Re: Planning Application 20/910

Address: Flats 1A and 1B Old Farmhouse Bawdlands Clitheroe BB7 2LA

Description: Demolition of existing two-storey building containing two flats to be replaced by three two-storey, three-bedroom houses. Creation of new car parking and landscaping on existing, adjacent allotment site.

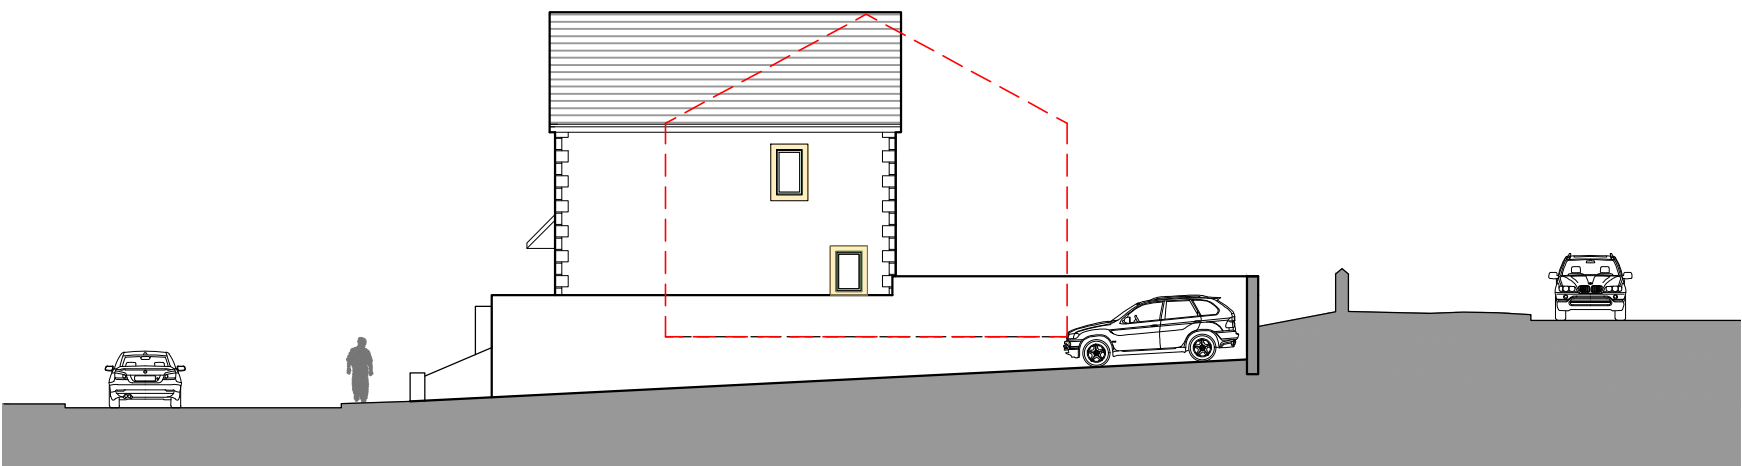
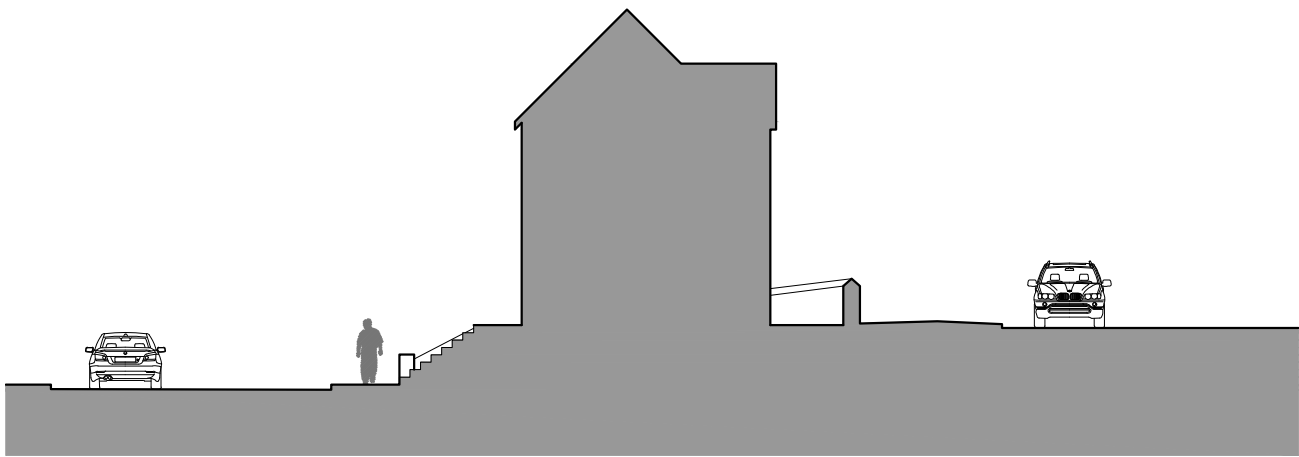
Secondly, the car park slopes towards Thorn Street it is expected that a drainage scheme is provided to prevent this area draining on the highway.

Finally it is noted that the wall adjacent to the site along Thorn Street is a retaining wall, details of measures to be taken to ensure that the stepped access retain the land are required.
